**RE: STONE AGE CLIMING GYM PERMIT NUMBER BP-2019-33977
TRAFFIC CERTIFICATION FOR PERMANENT CERTIFICATE OF OCCUPANCY
RESPONSES TO COMMENTS:**

Responses to comments by Ernie Gomez in letter dated 7-28-20:

Overall Site Plan

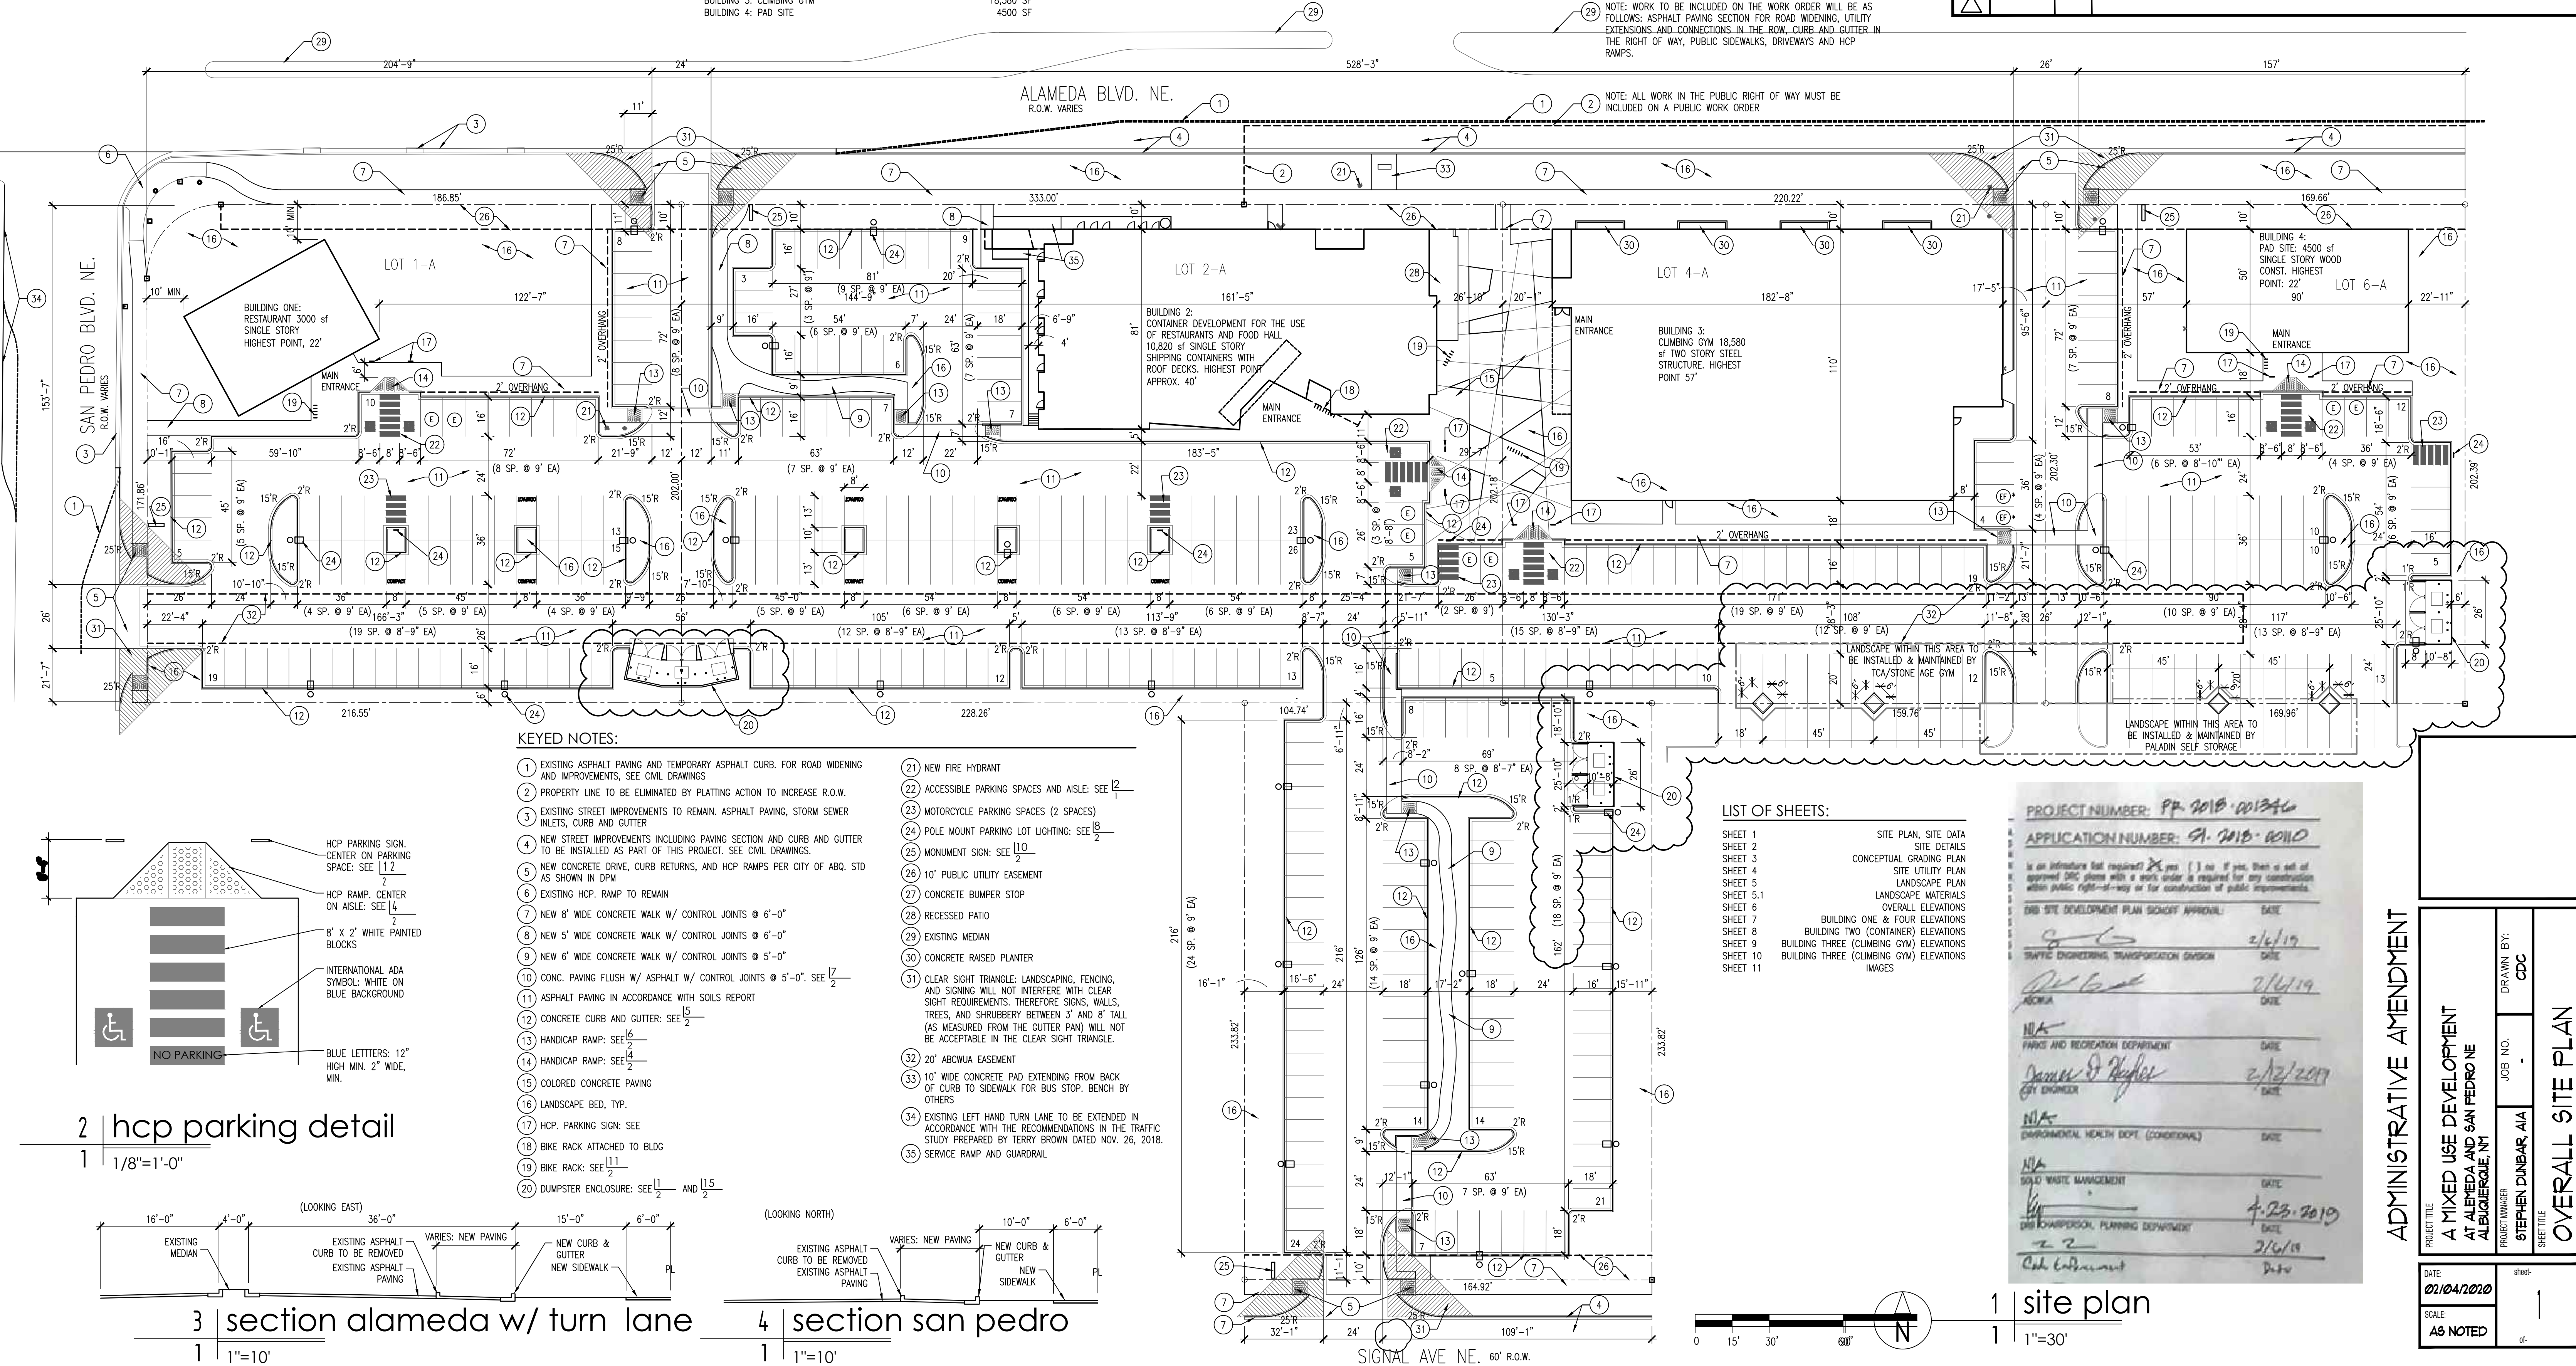
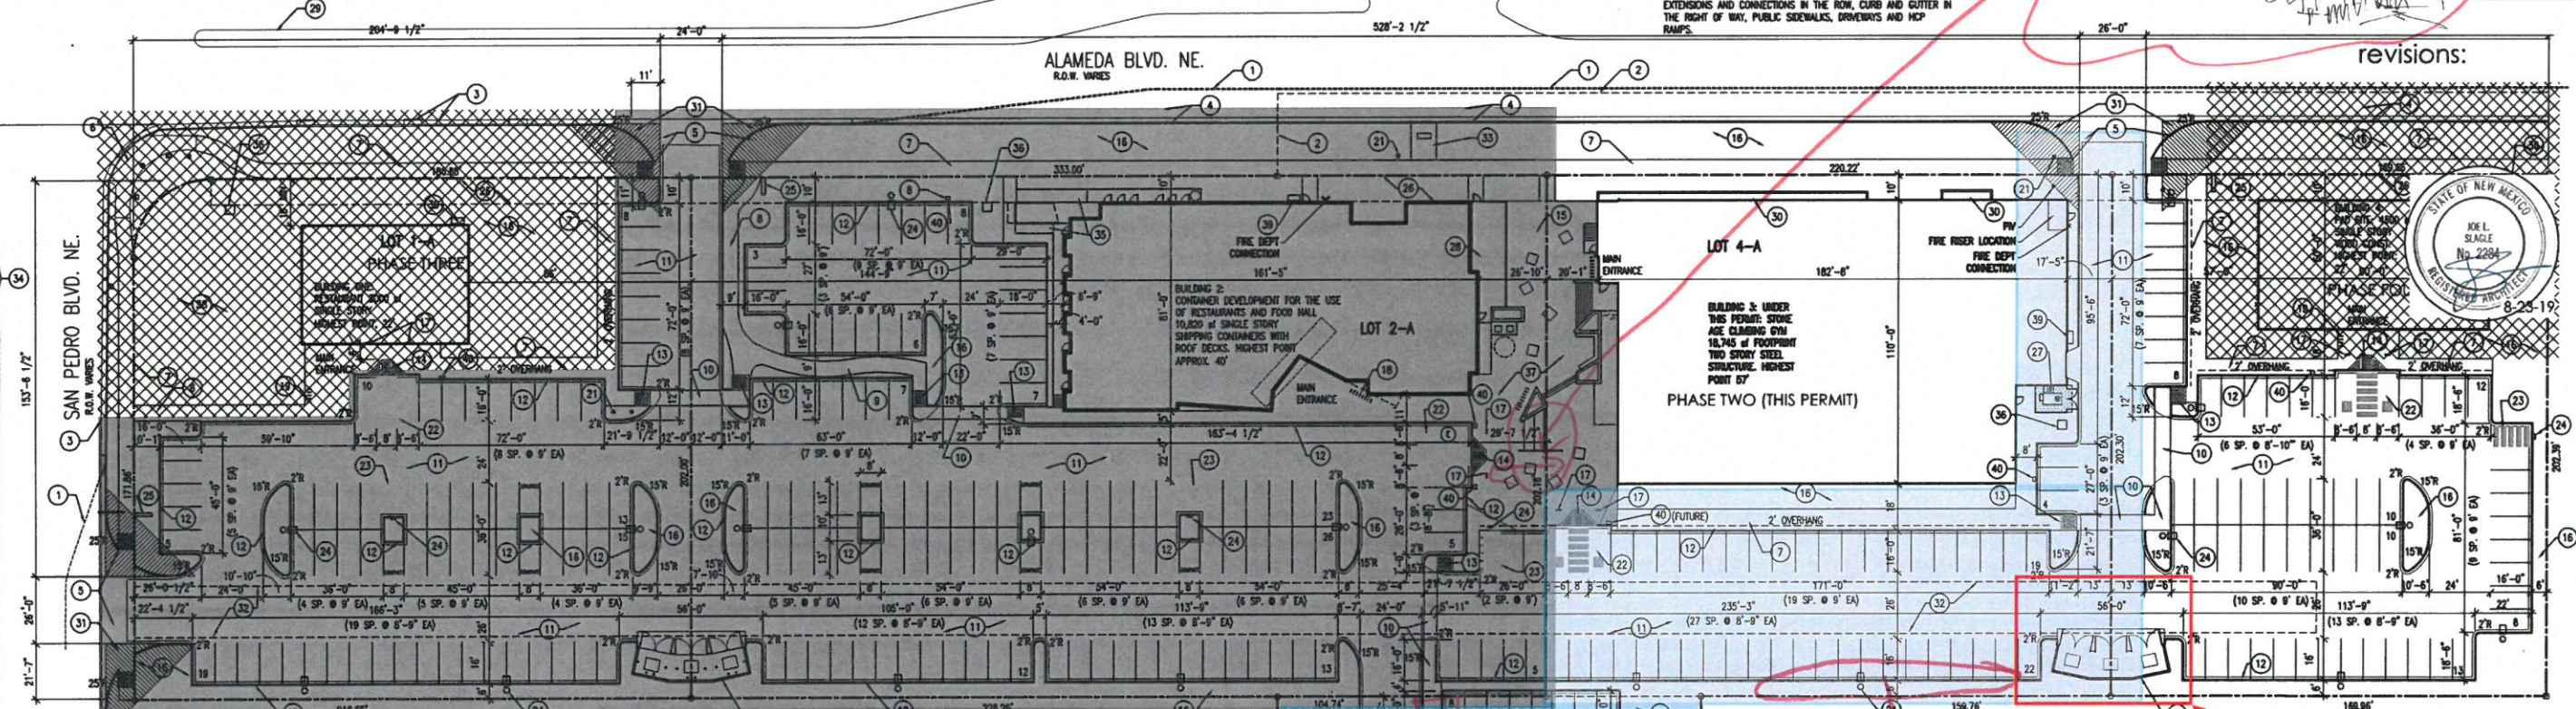
1. The ramps indicated on the marked up site plan have been removed and replaced with landings less than 2% slope in all directions.
2. The curb and gutter referred to on the marked up site plan is no longer part of the project. Please refer to the Administrative Amendment site plan by Modulus Architects for the current condition. Parking bumpers have been installed at this location until such time that the adjacent development is completed.
3. An accessible path has been created from the Stone Age hcp parking spaces to the Tin Can Alley entrance by the installation of handrails creating a compliant ramp. See attached plan and details.
4. Certification letter has been stamped and dated.
